From: Richard Castro-Parker
Sent: 05 September 2019 09:57
To: Samantha Lee
Subject: FW: BE/139/18/PL - Innovation Centre Beeding Close

From: Laura Gibbons
Sent: 30 August 2019 11:57
To: Richard Castro-Parker <Richard.Castro-Parker@arun.gov.uk>
Subject: RE: BE/139/18/PL - Innovation Centre Beeding Close

From: Richard Castro-Parker
Sent: 21 August 2019 12:10
To: Laura Gibbons <Laura.Gibbons@arun.gov.uk>
Cc: Daniel Vick <Daniel.Vick@arun.gov.uk>
Subject: FW: BE/139/18/PL - Innovation Centre Beeding Close

[illegible]

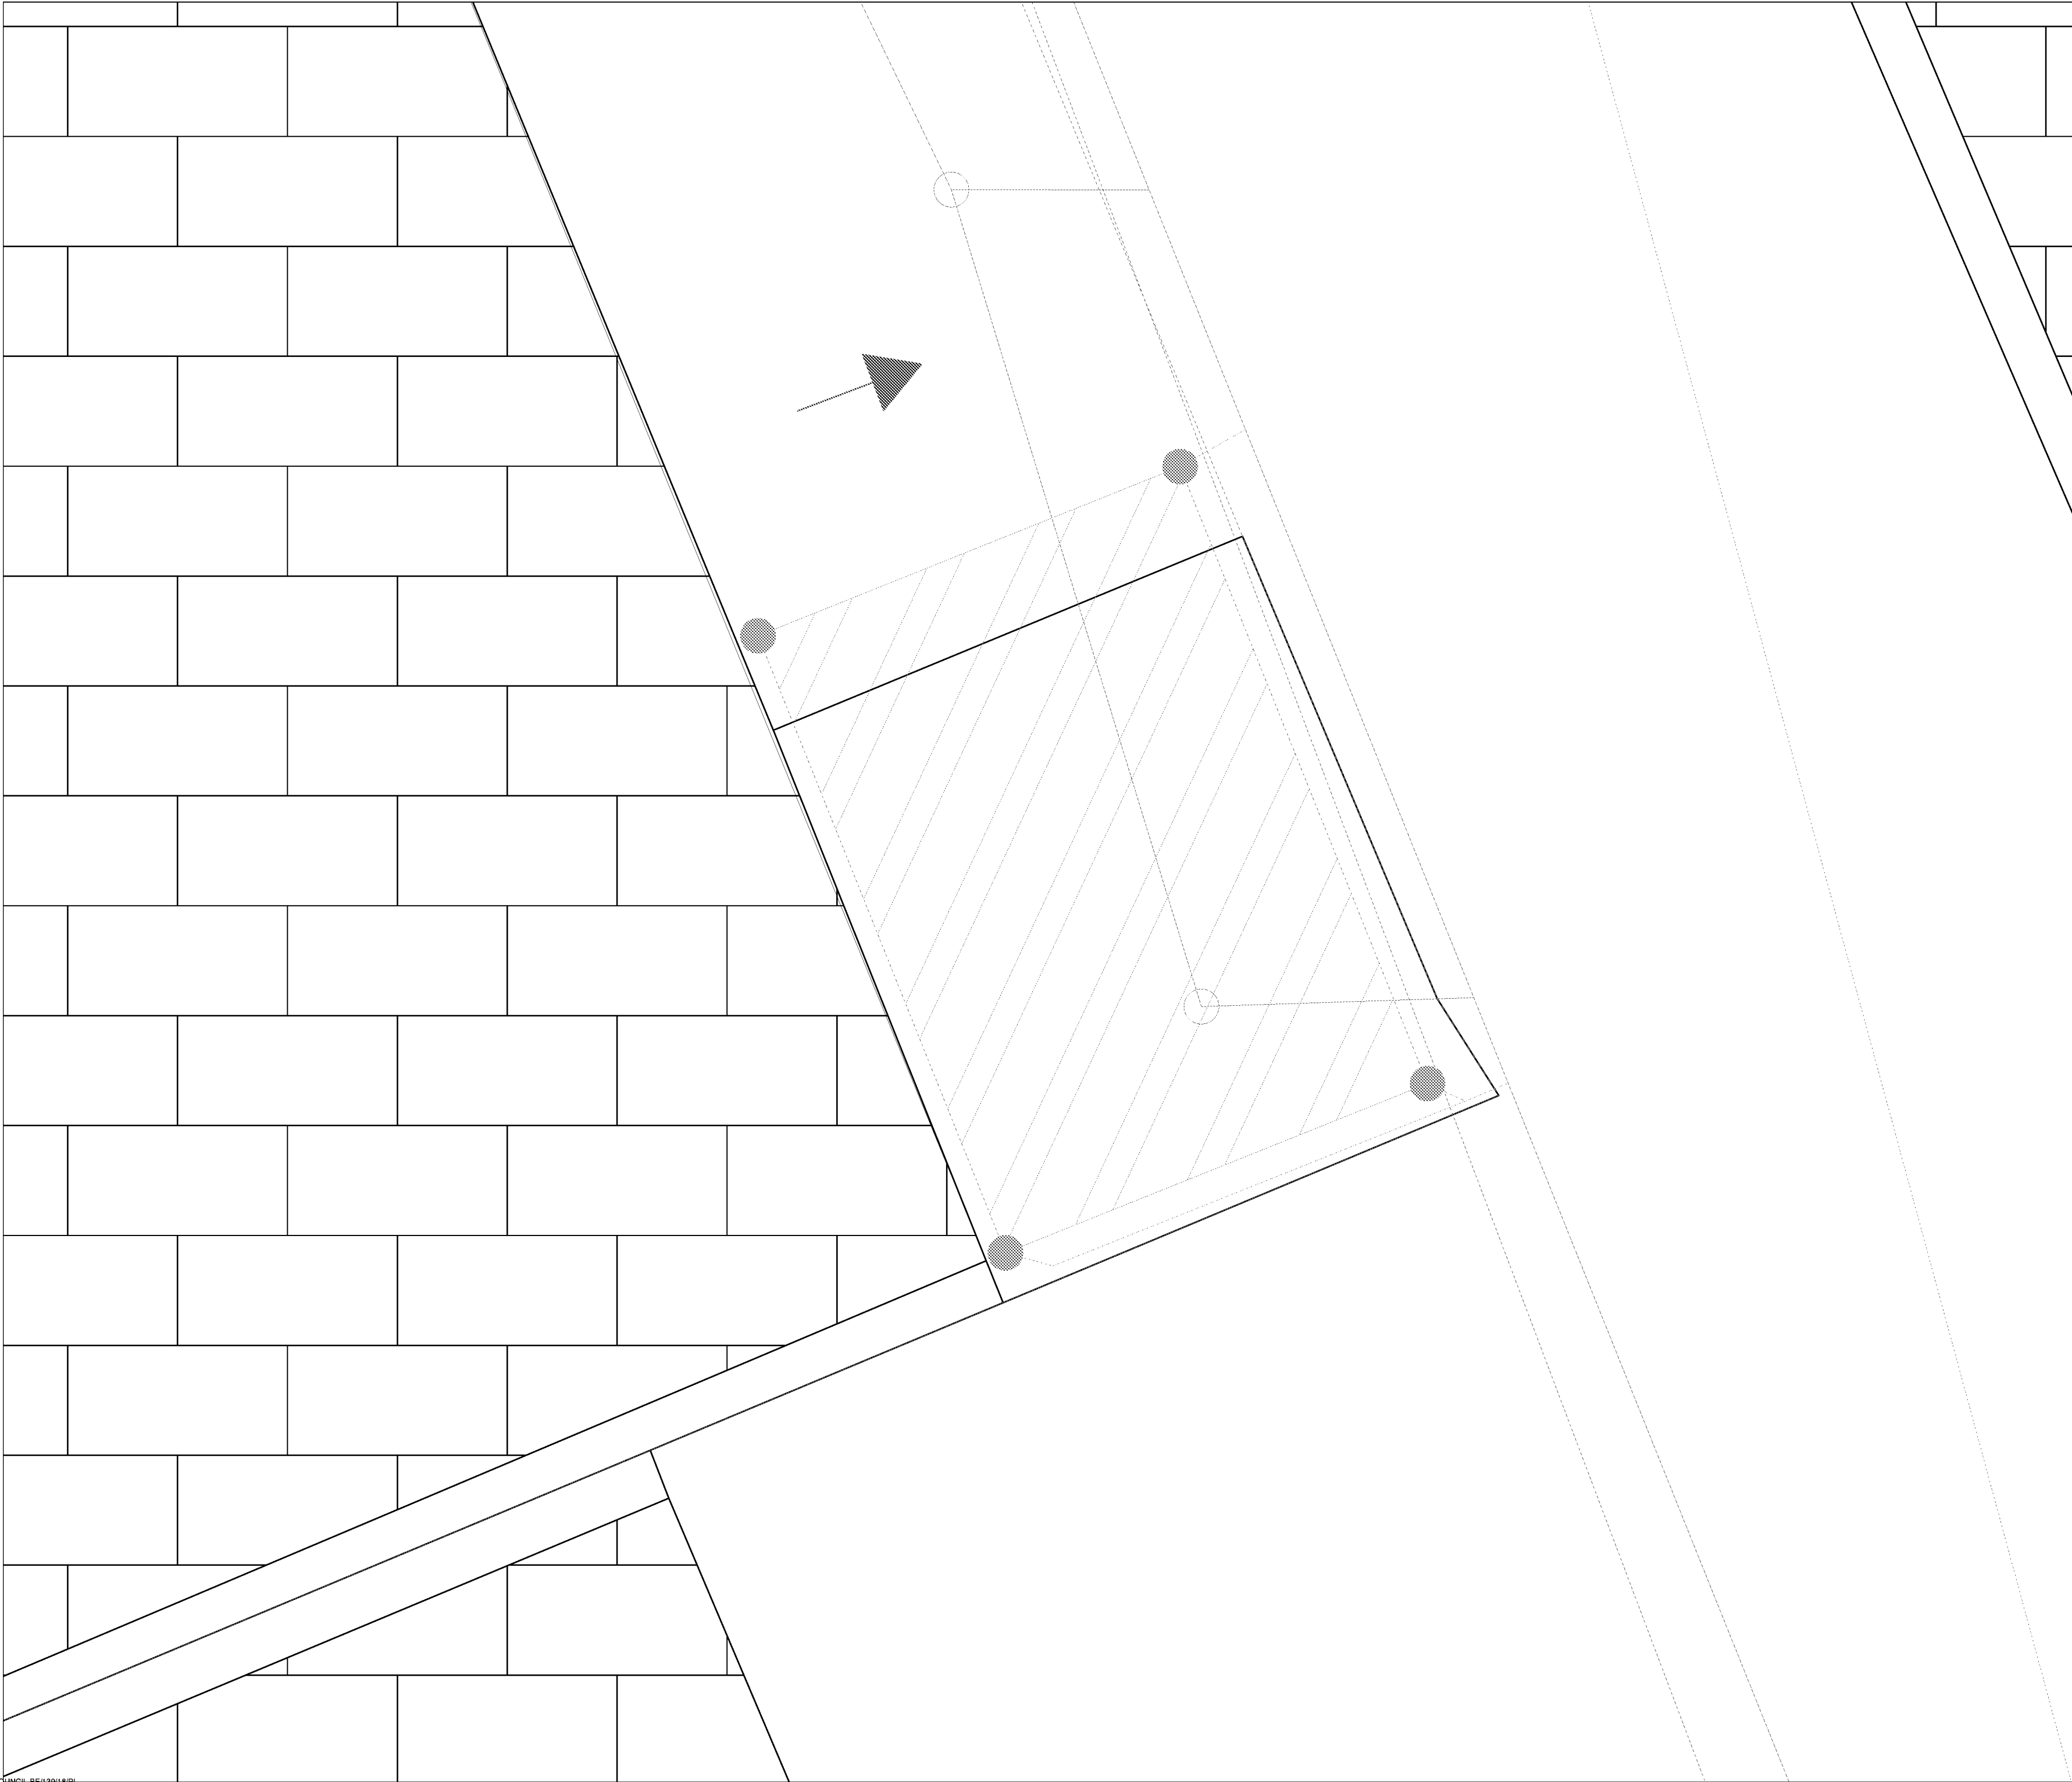
I still am struggling to distinguish between lines. Please can different line types be used, rather than all very similar colours. Please can gullies, manholes, and linear drainage channels be clearly labelled.

Regarding the levels, I also requested some spot levels of the surrounding land, can these be provided. This is fundamental to ensure that the surface water from the development does not go off site.

Please can the applicant submit clearer plans of the proposed surface water drainage arrangement. I.e. different line types used, rather than all very similar colours. Please can gullies, manholes, and linear drainage channels be clearly labelled.

I also require levels to be submitted showing invert and cover levels of the existing drainage network and spot levels of the surrounding land. This is fundamental to ensure that the surface water from the development does not go off site.

Please find attached a PDF of the drainage layout plan for the site. Given the size of the site, all lines on the plans are small. However, if Laura zooms in she will be able to distinguish between the pipes types. This should hopefully address her first concern.

With regards to levels, having reviewed the sewer asset location search requested from Southern Water, both invert and cover levels for all Southern Water manholes are detailed within their response. A copy of the sewer asset location search was included within the appendix of the Surface Water Drainage Strategy – this have been attached to this email for her reference.
